**COMMUNITY SERVICES DEPARTMENT**

September 15, 2021

**Subject: Eagle Forest Filing No. 1 Final Plat – (SF2131)**

EAGLE FOREST SUBDIVISION FILING NO. 1

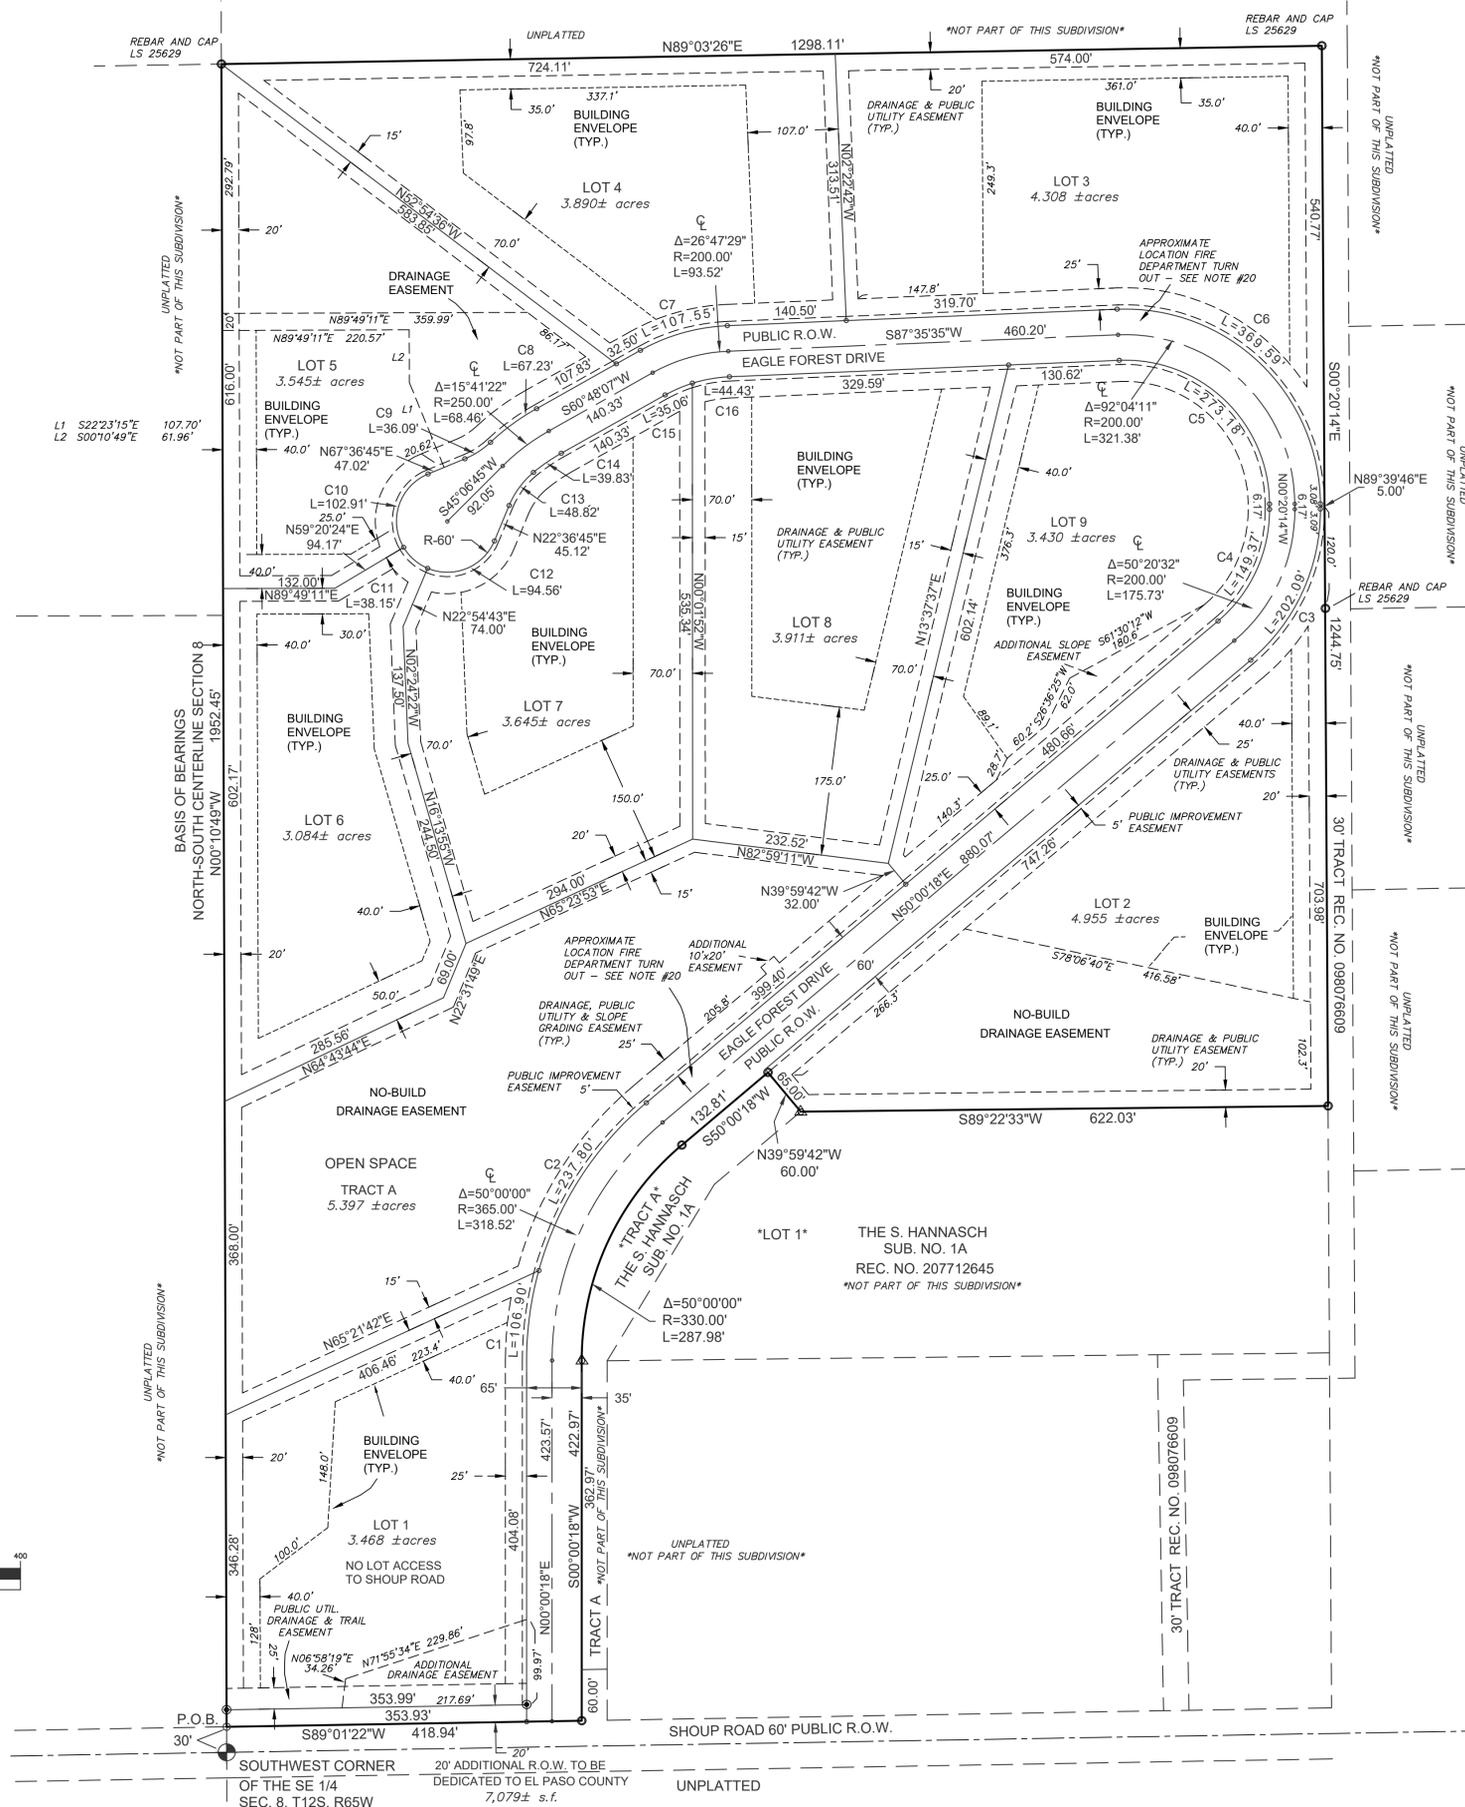
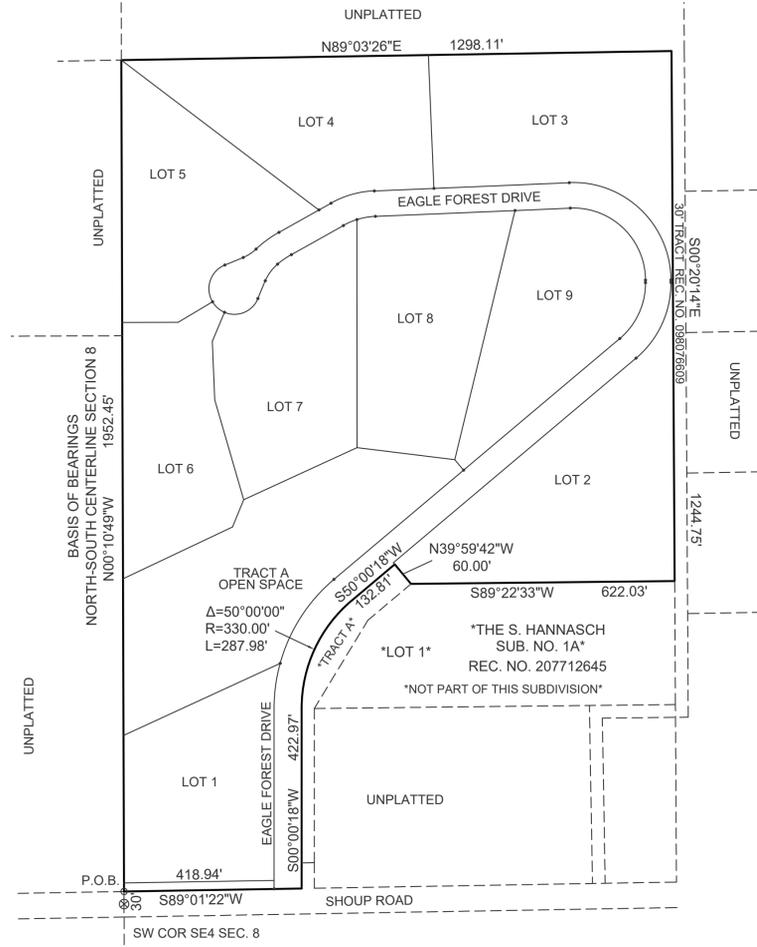
Bicycle Route is not impacted by the project because it is located in the public right of way. The proposed Black Forest Primary Regional Trail along Shoup Road is within the project area on the north side of Shoup Road. The letter of intent mentions that a 25-foot trail easement will be dedicated to El Paso County along Shoup Road however, the easement is not shown on the final plat drawings.

County Parks requests trail easements where development projects impact proposed County trails. As it pertains to this application, the County requests that the applicant provide a 25-foot public trail easement along the north side of Shoup Road that allows for the construction and maintenance by El Paso County of the Black Forest Primary Regional Trail, and this easement shall be shown and dedicated to El Paso County on the Final Plat.
